Application No: FP/220/20/PL
Site Address: Kenwood Court 6 The Midway Felpham PO22 7EZ
Description of works: Car port and rearrangement of existing parking spaces.

Thank you for your internet representation made on 15th January 2021 which has been recorded as an objection with the comments as follows:

PROPOSED CAR PORT
PLANS AND ELEVATIONS

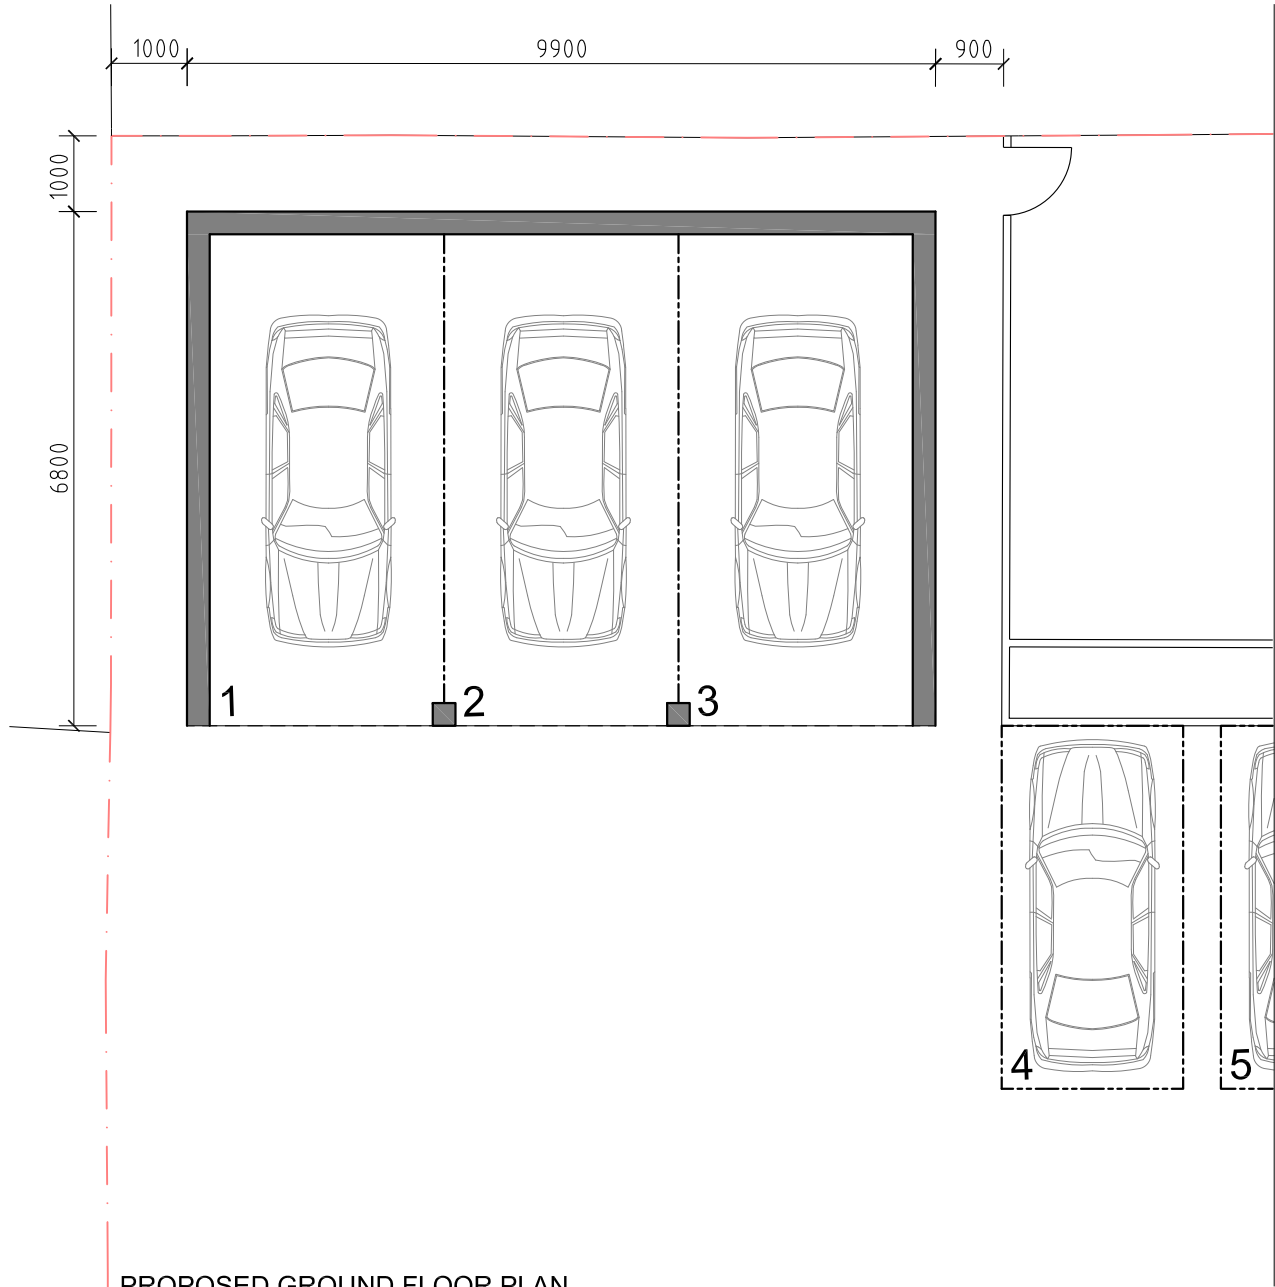
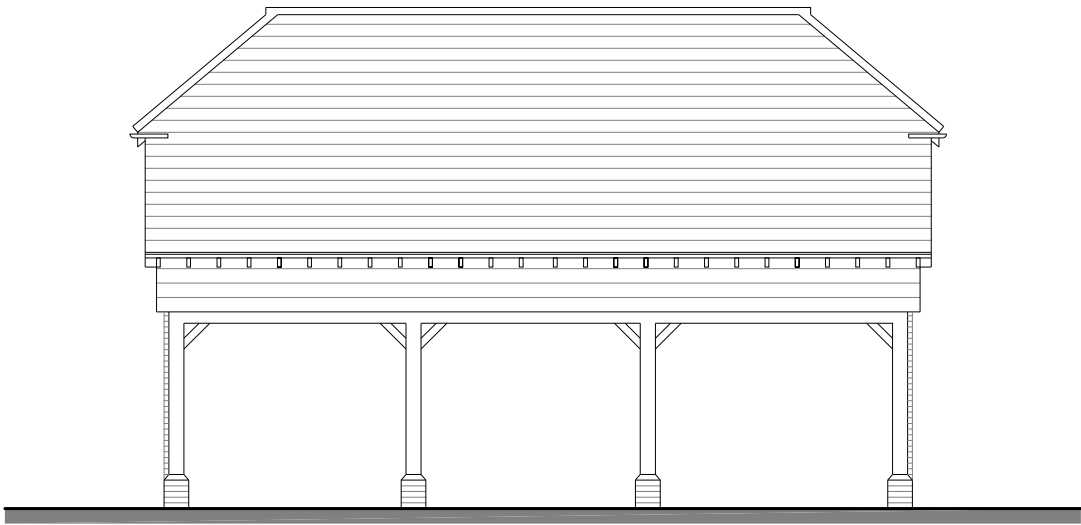
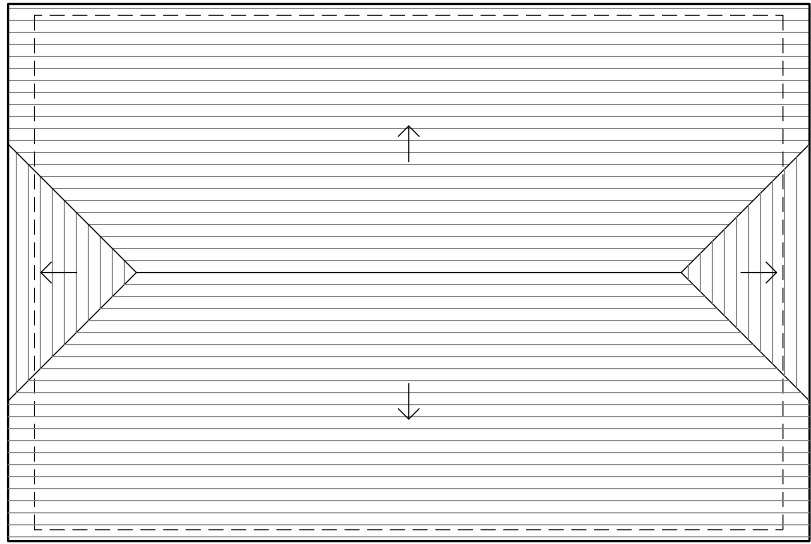
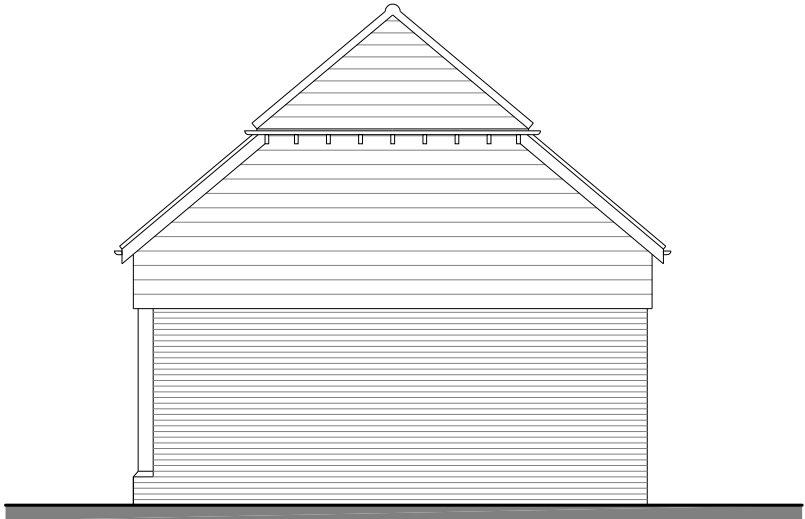
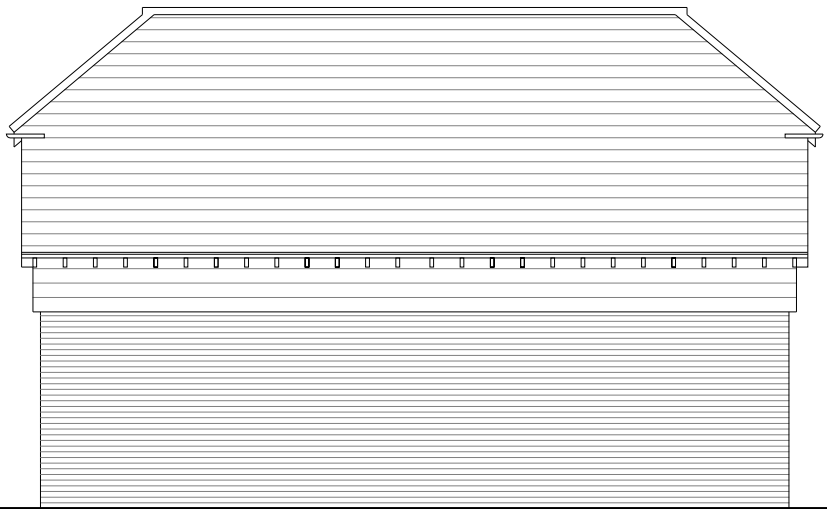
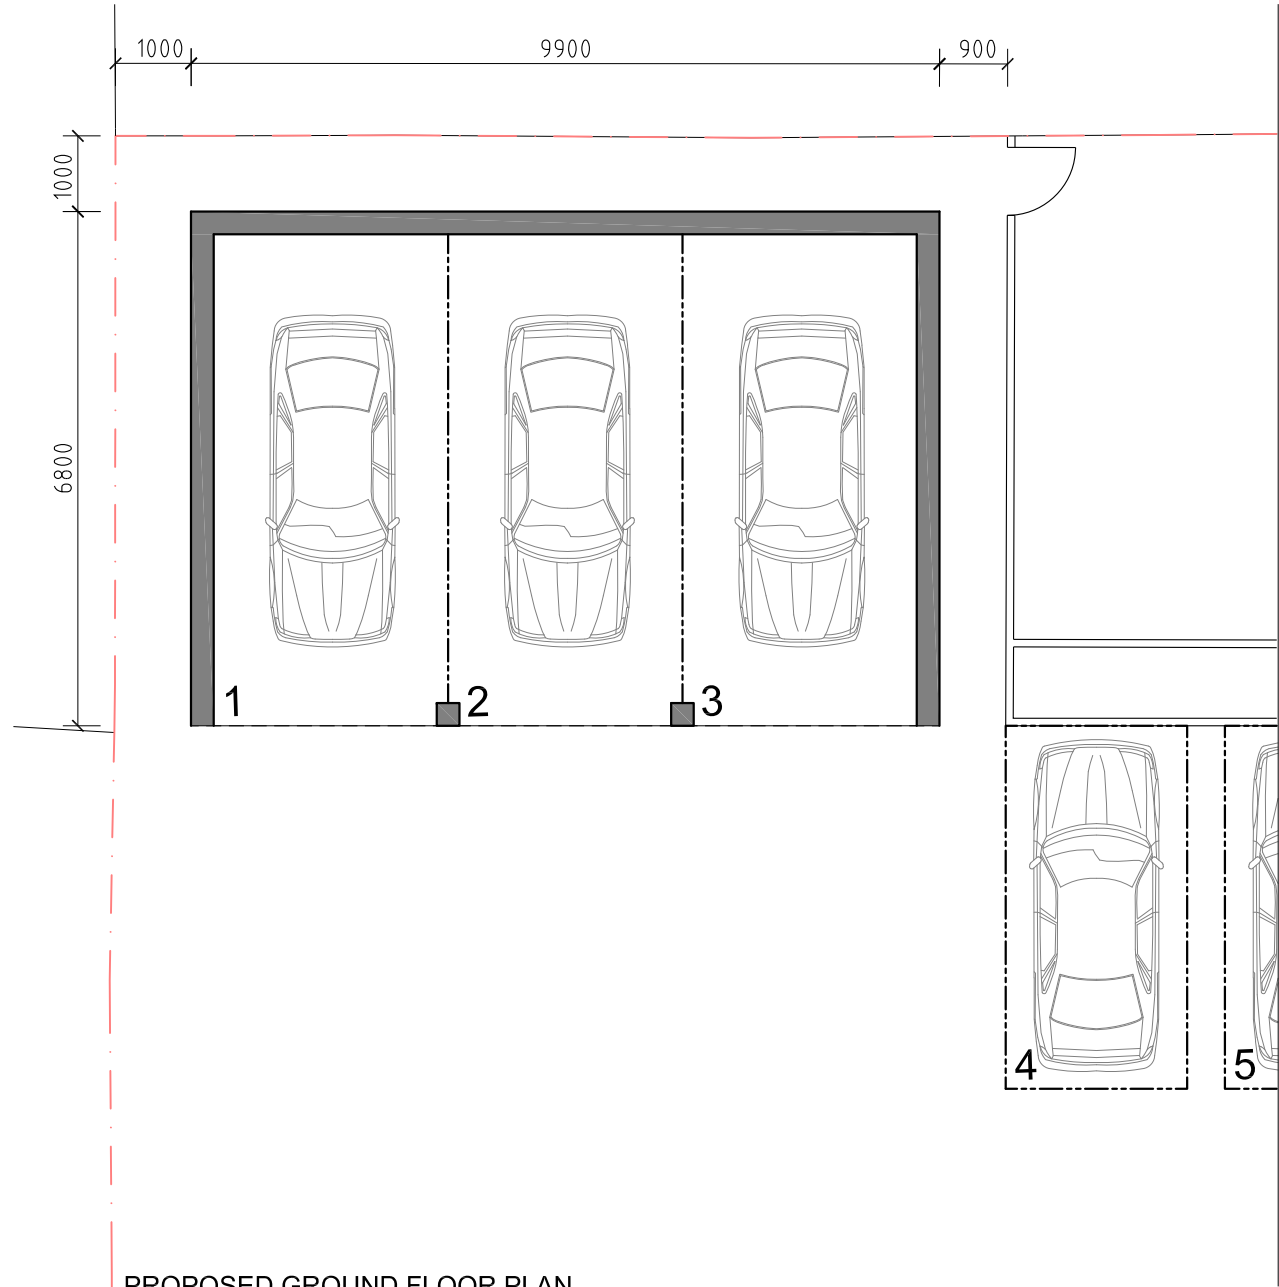
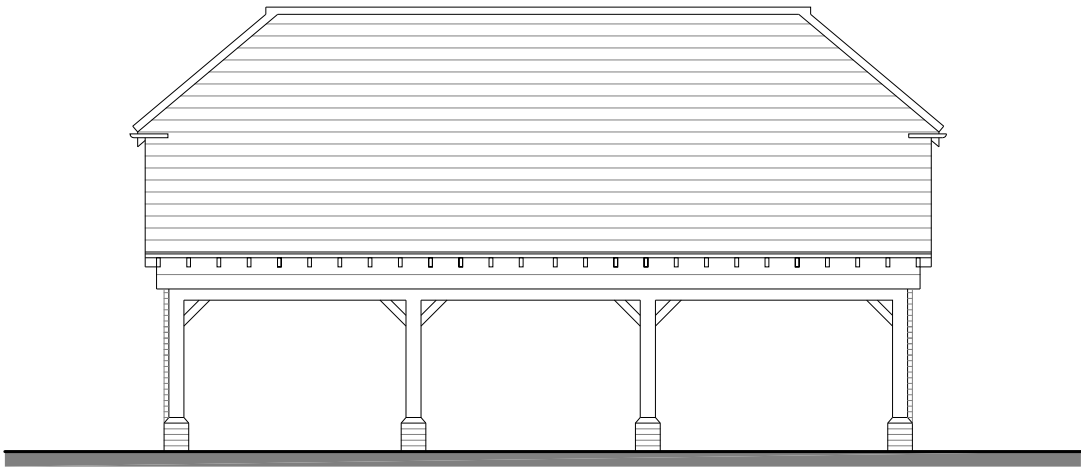
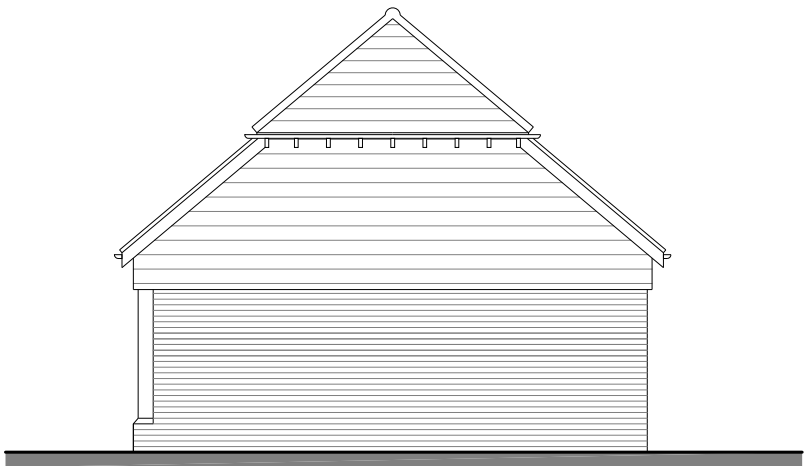
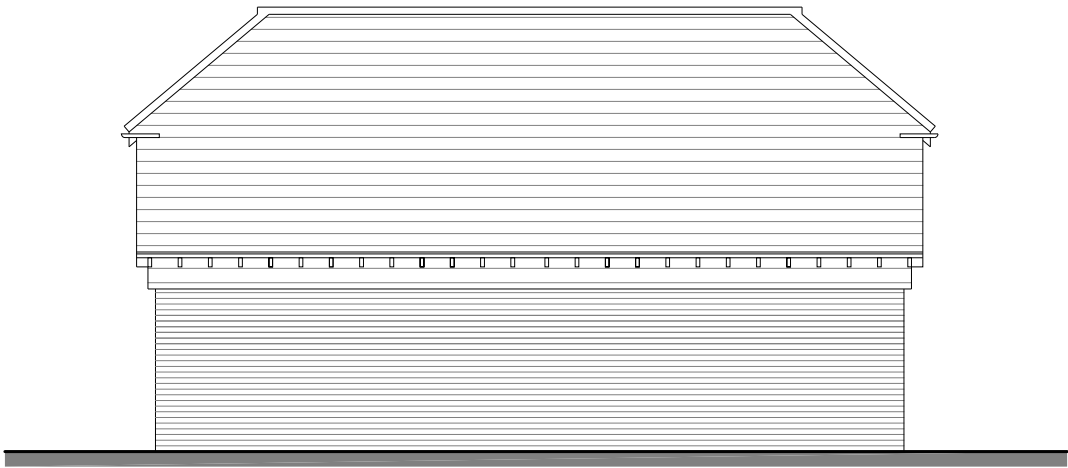
We have concerns regarding the height of the structure bordering our garden to the south (3 car park spaces), and the considerable impact on the light/shadow on the garden. The height of the structure will also block the view of greenery and instead show the back of a large building.
